Reference No:	2024/62/92152/E
Site Address:	489, Bradford Road, Birkenshaw, BD11 2DS
Description:	Erection of two storey front and single storey side extensions
Recommending Officer:	Elenya Jackson

DECISION – CONDITIONAL FULL PERMISSION

OFFICER REPORT

DRAWING
PROPOSED FLOOR LAYOUTS AND TYPICAL SECTIONS THROUGH.

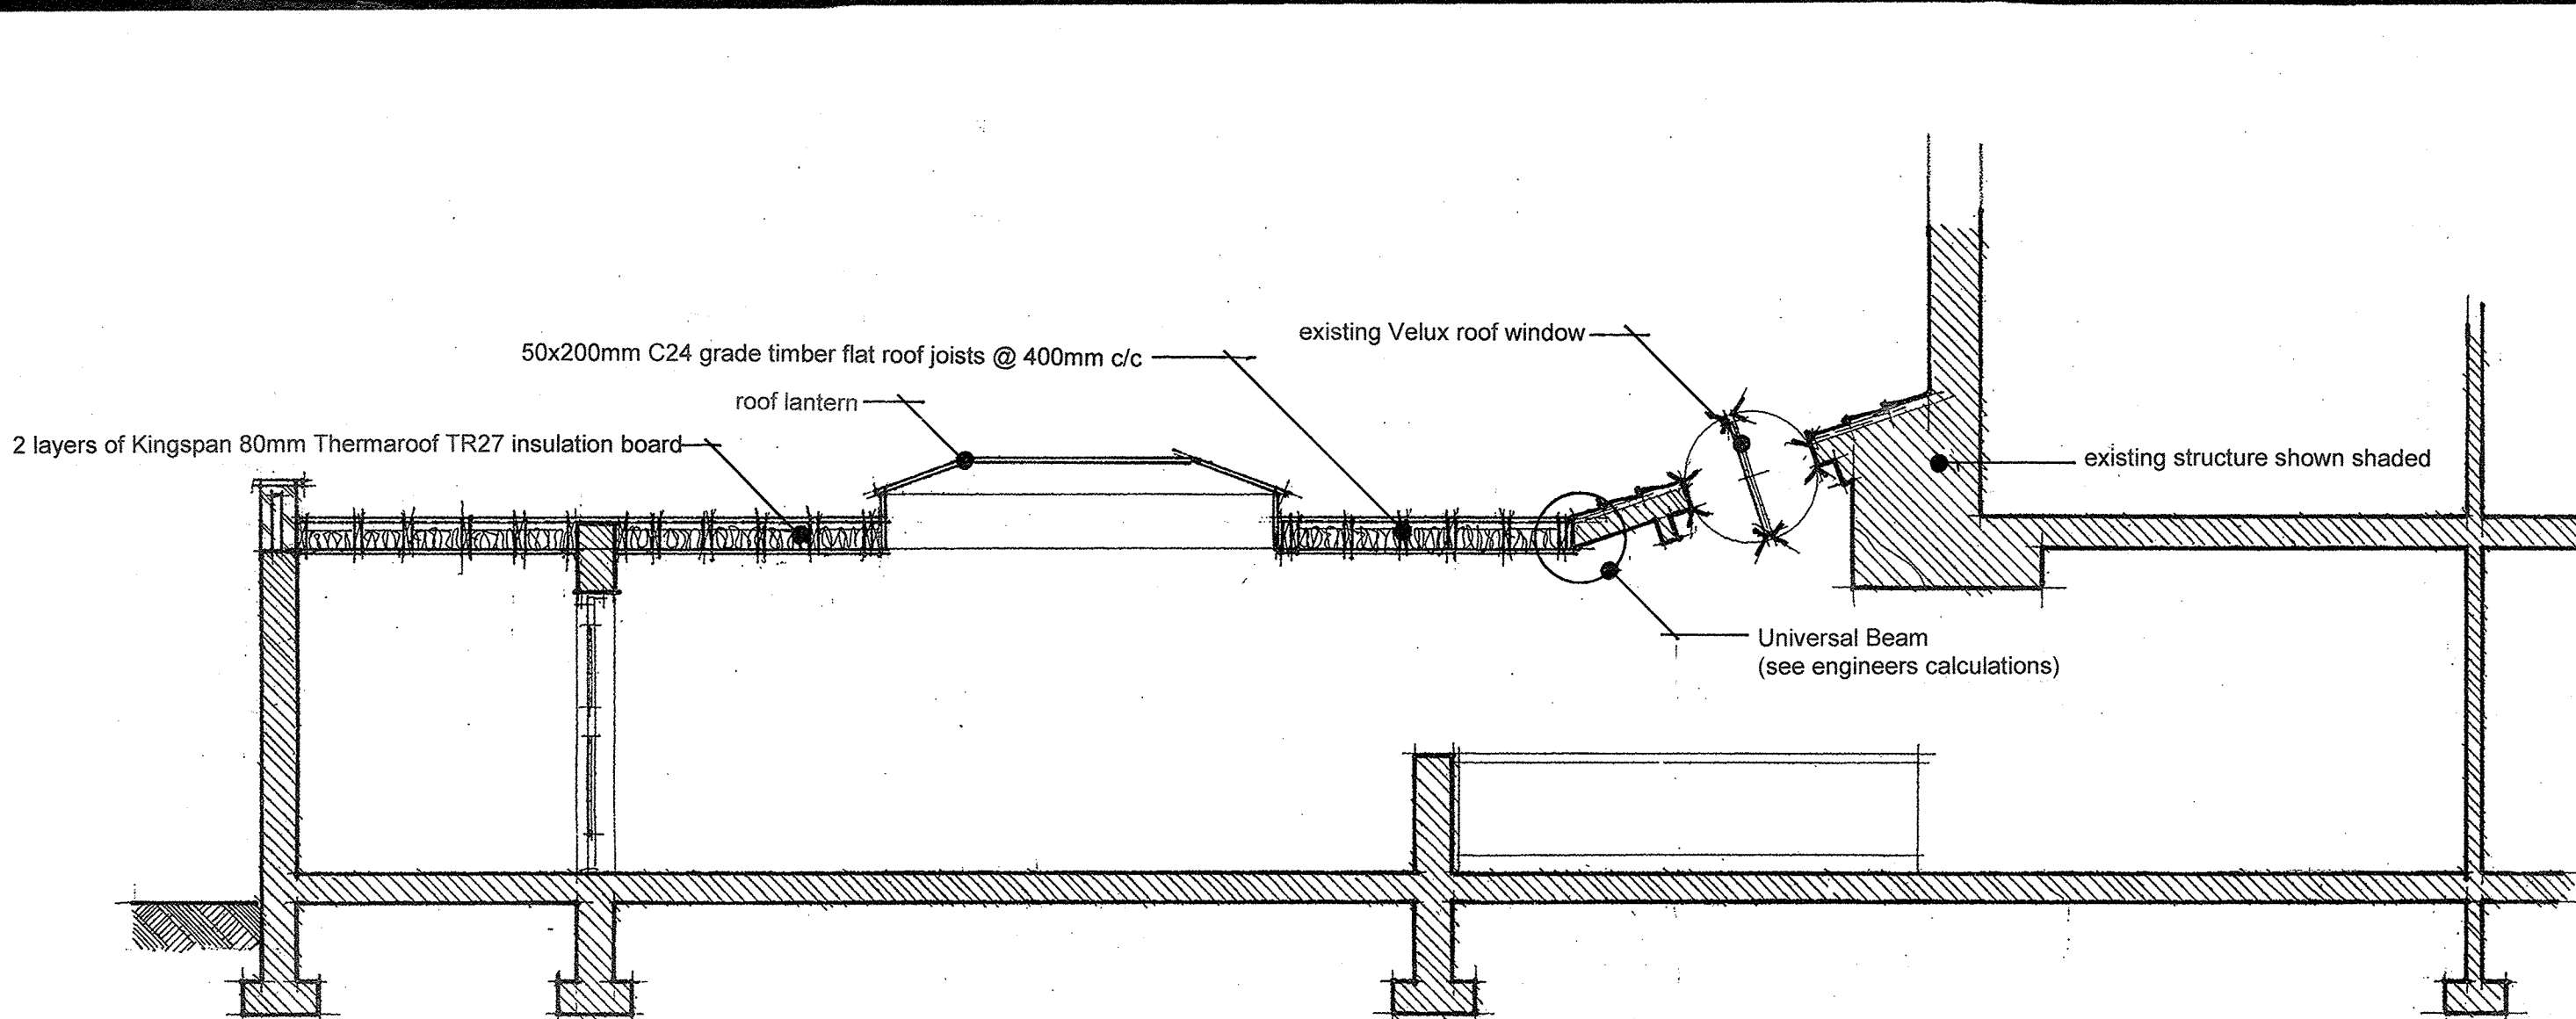
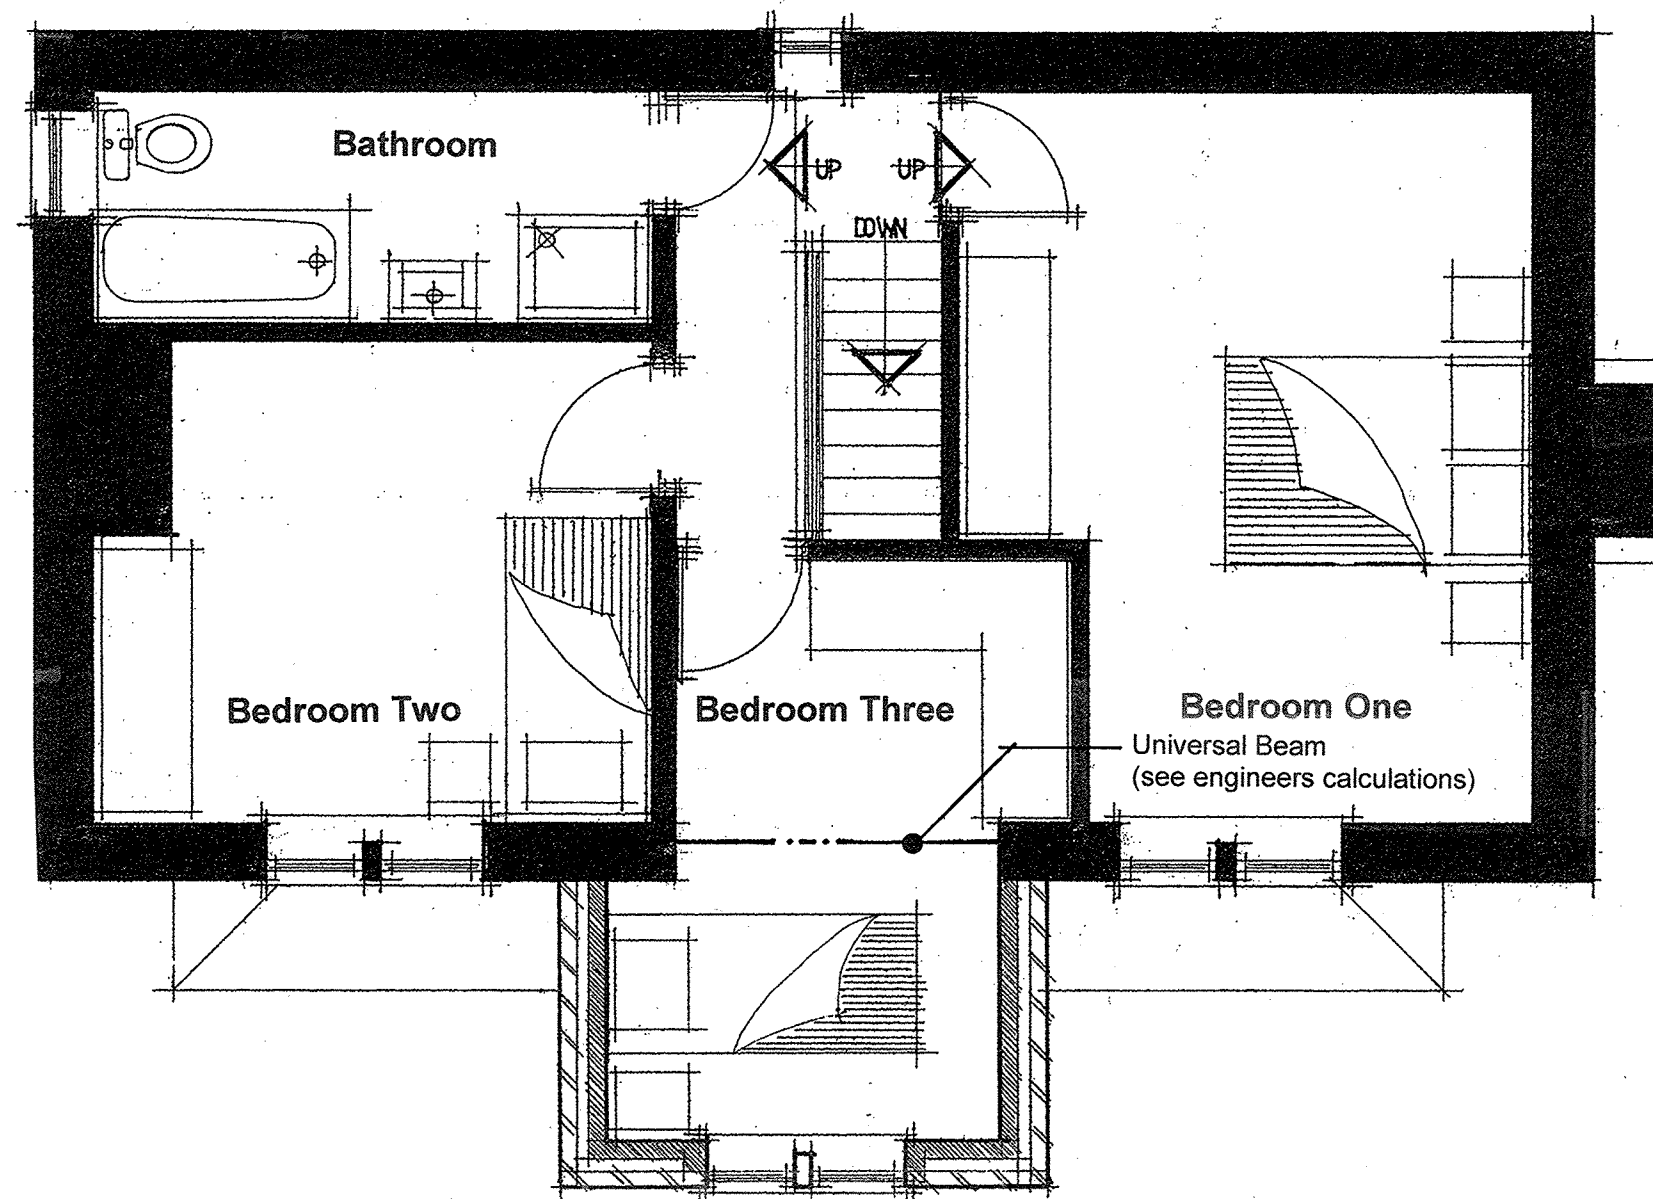
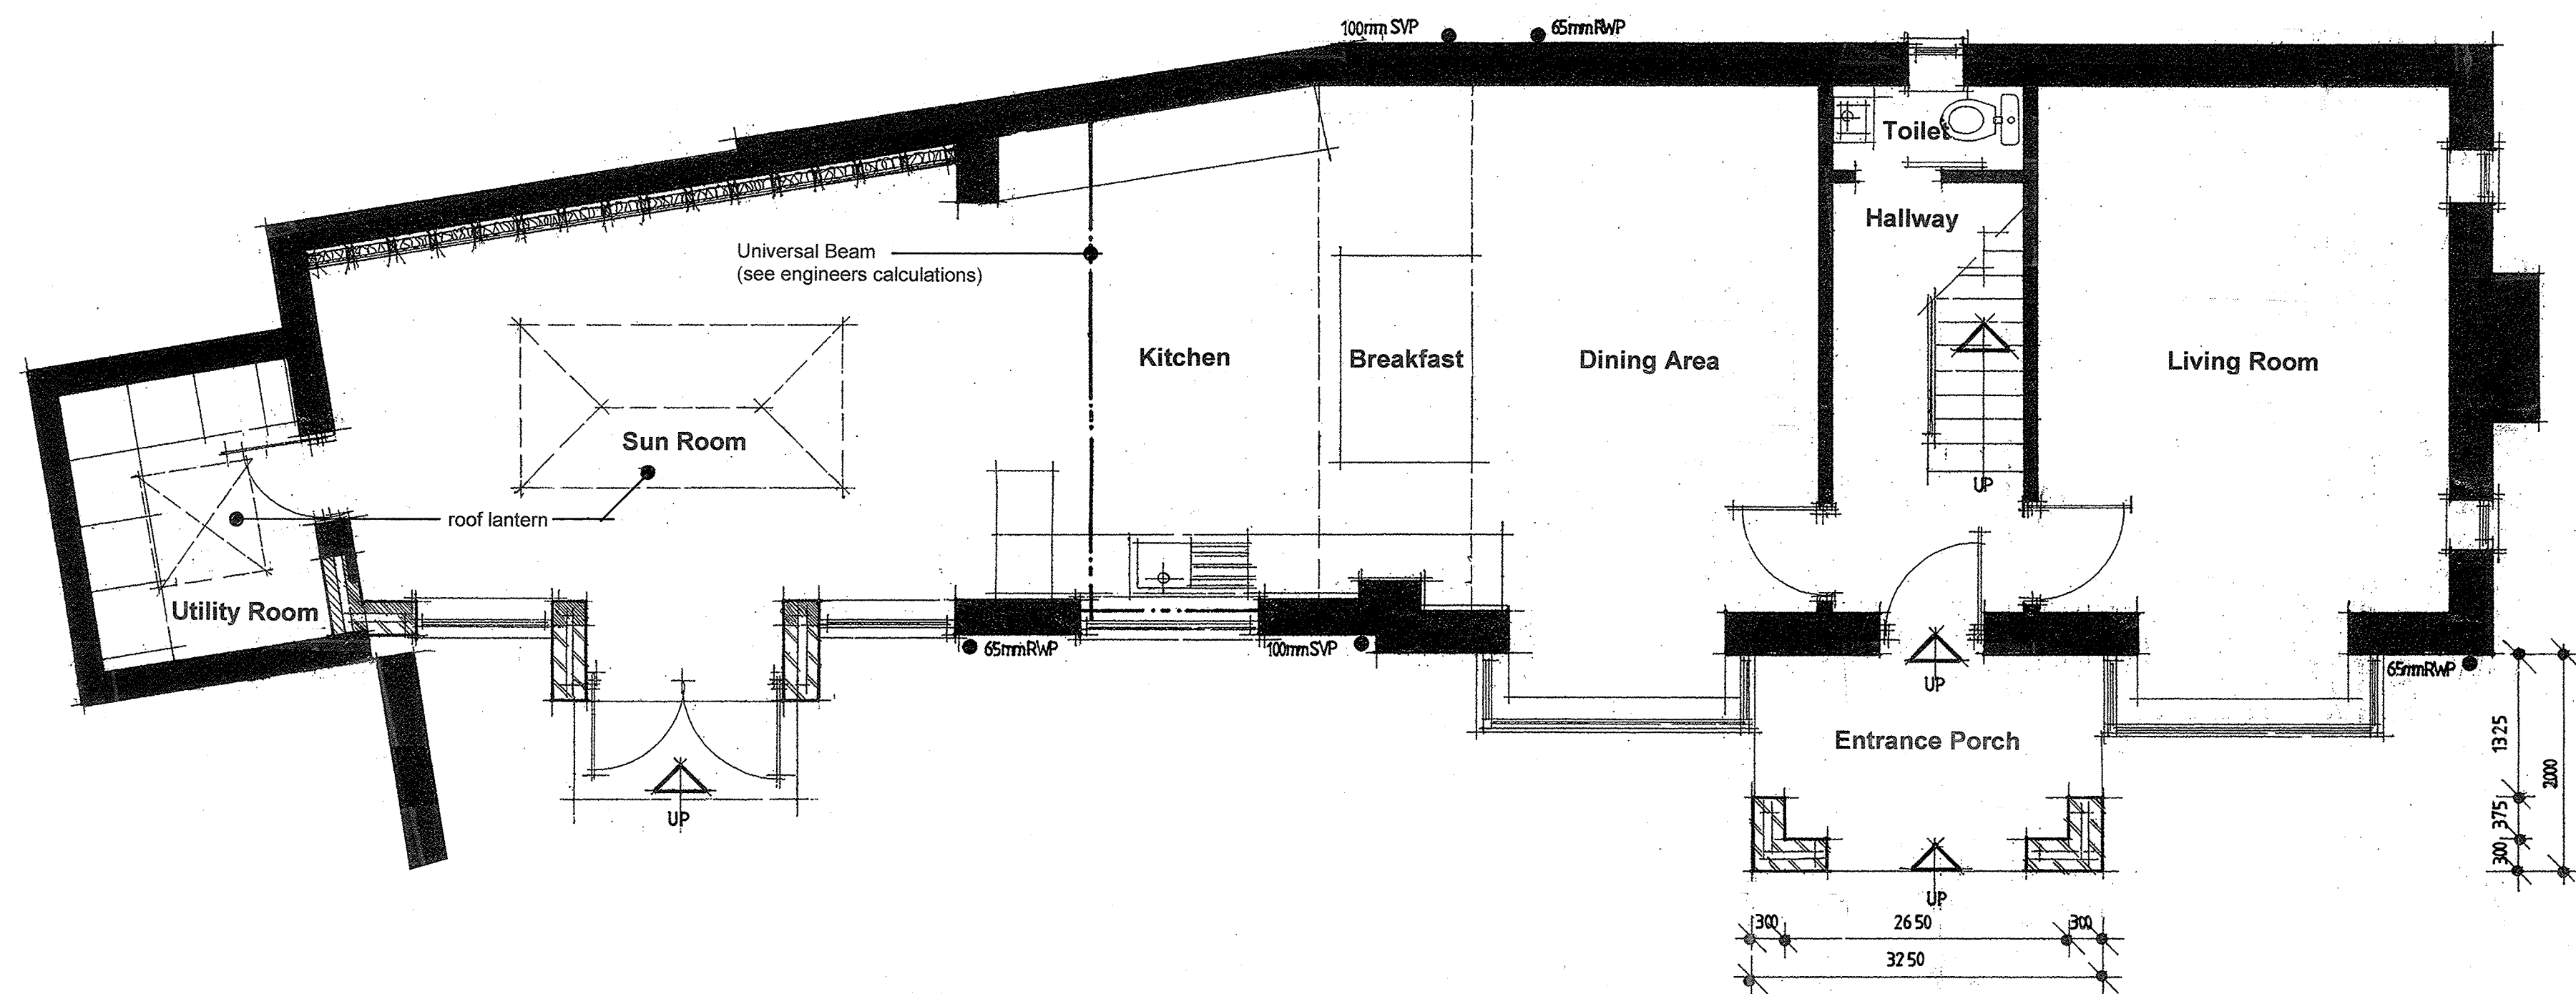
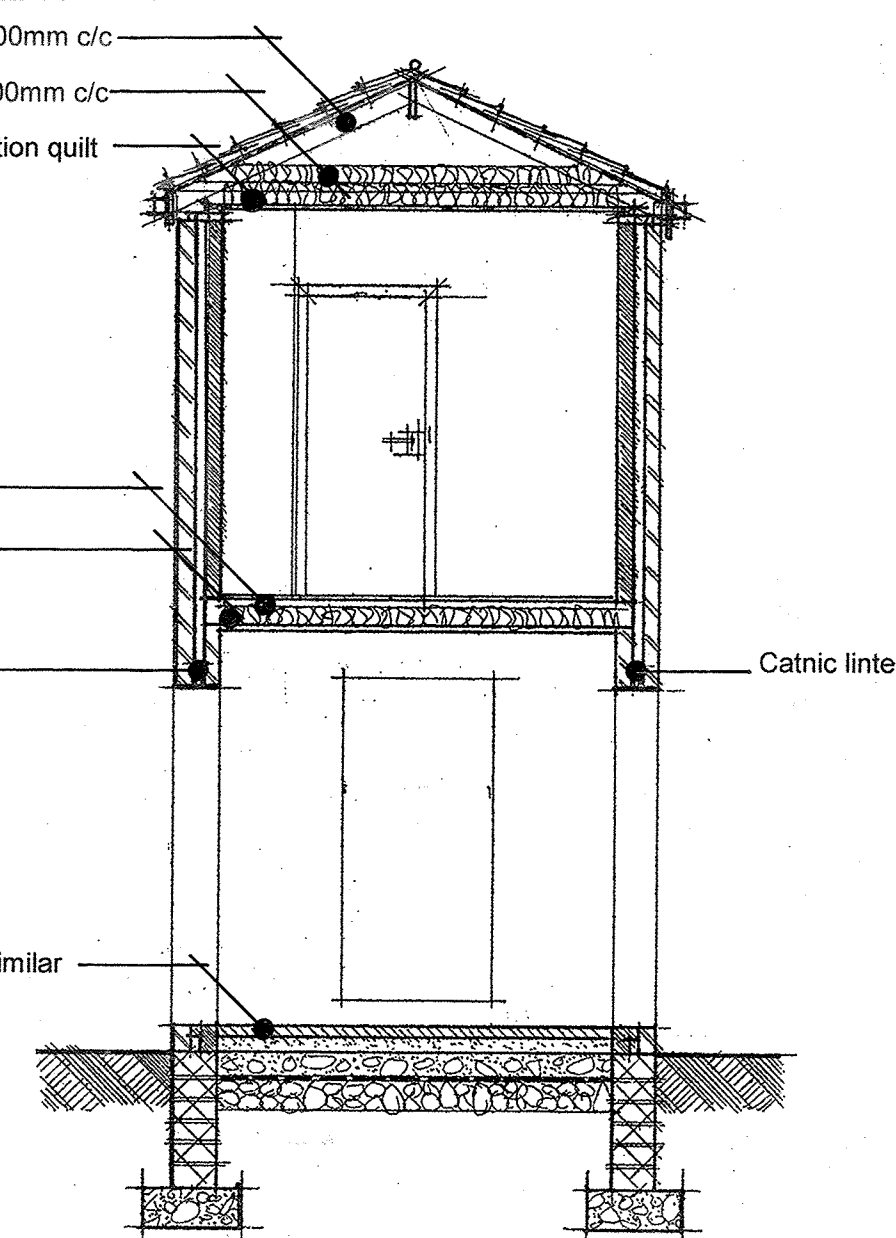
The two storey front extension would project 2m beyond the principal elevation of the dwelling and have a width of 3.3m. The proposal would have height of 6.7m and an eaves height of 5.9m.

The single storey extension would have a width of 11.9m and a depth of 5.5m. This would feature a flat roof with a maximum height of 3.2m.

The single storey extension would largely have the same footprint as the existing single storey projection and a maximum height of 3.2m. There would be no additional windows in the rear or side elevation and therefore no significant issues would arise regarding overlooking.

DRAWING
PROPOSED ELEVATIONS AND SITE LOCATION PLAN.

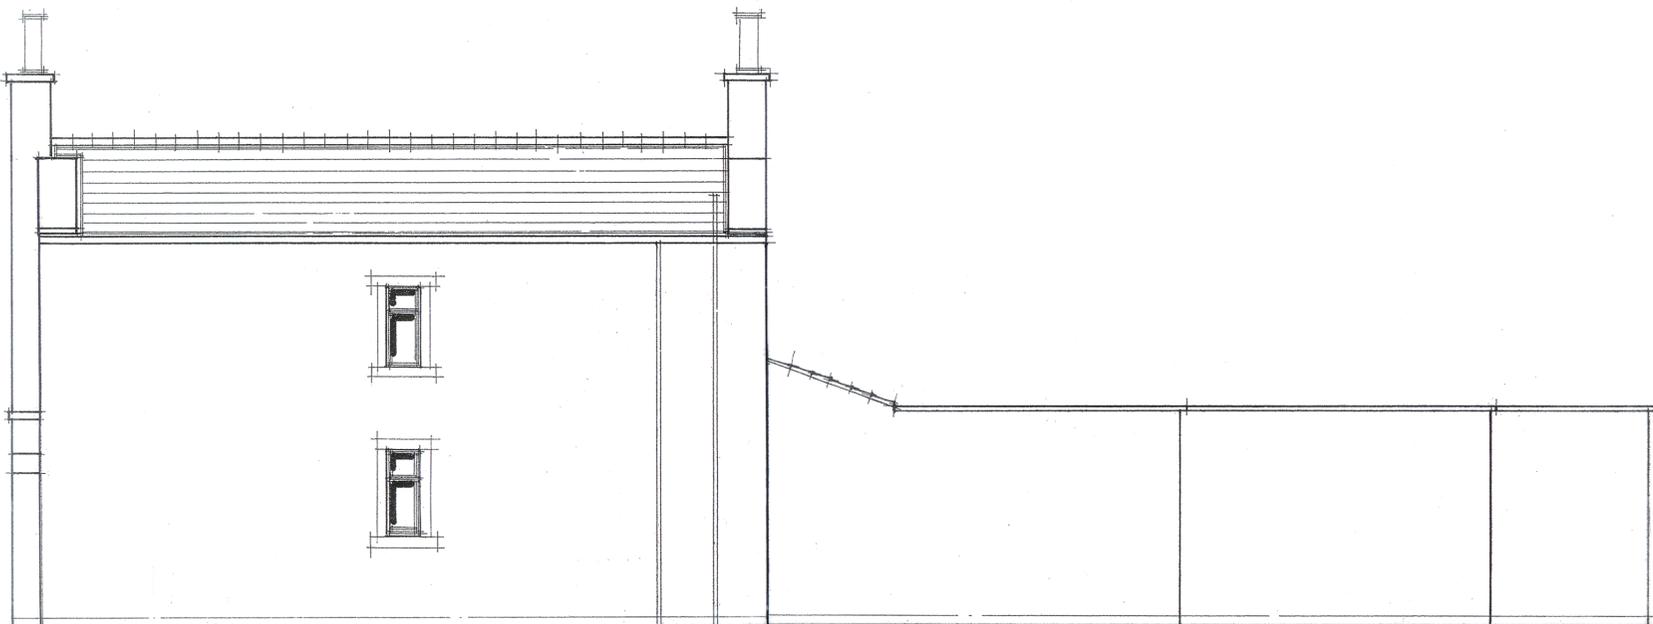
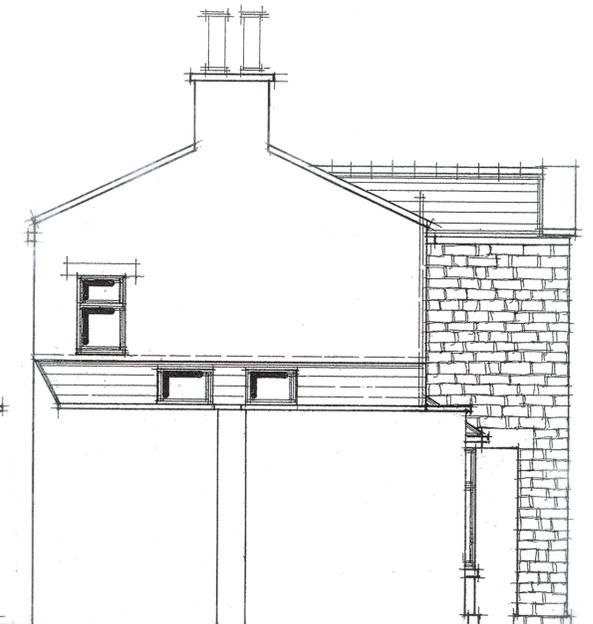
Officers consider that the orientation of the dwelling would result in the proposal being well screened from the public realm which would aid its integration. The proposal would not cover the full width of the dwelling which would prevent it from appearing incongruous to the host dwelling. The proposal would be constructed out of materials appropriate to the host dwelling.

Whilst the extension is two storey, it is to serve a dwelling which is of an individual design within the street and is not considered to be such that it would significantly alter the overall appearance of the host property or wider street scene. The proposed extension is of a design which is in keeping with the design features of the host property and on the basis it is constructed from materials which in all respects match those used in the construction of the existing dwelling it is considered the proposal would be acceptable having regard to Section 5.2 of the HEASPD.

In terms of the single storey side extension, section 5.3 of the HEASPD refers to side extensions. This states that the width of the proposal should not be more than 2/3 of the original house, not exceed 5m in height and be set back. It is acknowledged by officers that the proposal would not accord with aforementioned points; however, the dimensions of the proposal follow that of the existing footprint of development on site. The design would be more in keeping in terms of materials of construction and it is considered that by comparison to the visual impact of the existing dwelling and existing structures in place the proposal would not have a significantly greater visual appearance than that which exists already. Therefore, the proposal is considered acceptable in the context of the host dwelling and wider site. This element is recommended to be subject to condition requiring the materials of construction to match those used in the construction of the host property.

The front extension would be set central in the principal elevation of the host dwelling. It would not feature any side facing windows to raise any concerns regarding overlooking and the separation distance from neighbouring dwellings would be sufficient enough to not raise any significant concerns regarding overshadowing/loss of light/overbearing.

3. The external walls of the single storey extension to side and external walls and roofing materials of the two storey front extension hereby approved shall in all respects match those used in the construction of the existing building and be retained thereafter.

4. The flat roof of the single storey extension to side hereby approved shall be used as a roof area only and shall not be used as a balcony or terrace area at any time throughout the lifetime of the development.
